Please ask for: Mrs D Johnson
Email: daun.johnson@arun.gov.uk
Telephone: 01903 737762
Our Ref: AW/93/21/CLP
Your Ref: Mr Butterworth
Date: 19th March 2021

Lawful Development Certificate for a Proposed Use or Development

Development: Lawful development certificate for the proposed replacement of UPVC conservatory with a similar but larger version, replacement of all UPVC windows with similar, concrete rendering to all four brick elevations & construction of pitched/ponded roof over previous flat-roof extension.

Location: 35 Willowhale Avenue Aldwick PO21 4BG

Location Plan showing 35 Willowhale Avenue (in pink)

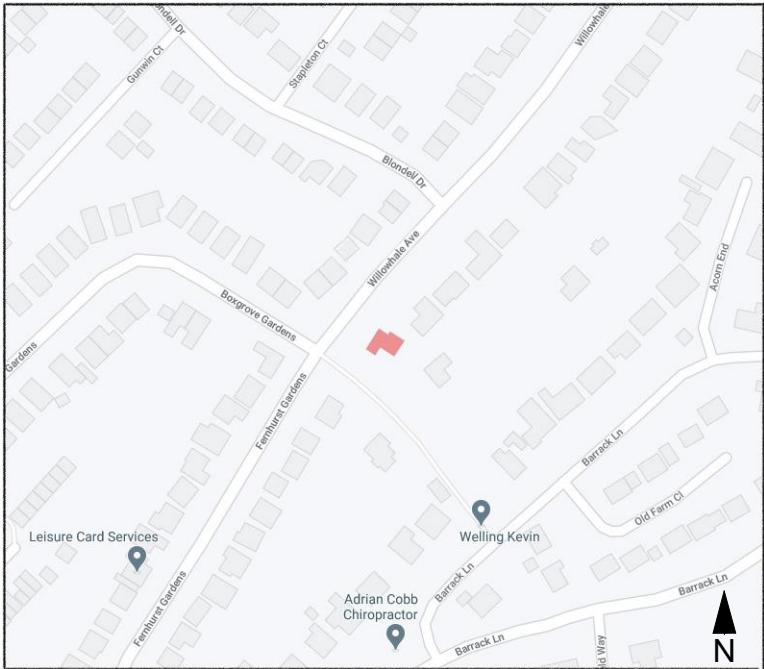
Location Plan

Please provide this plan at an identifiable scale.
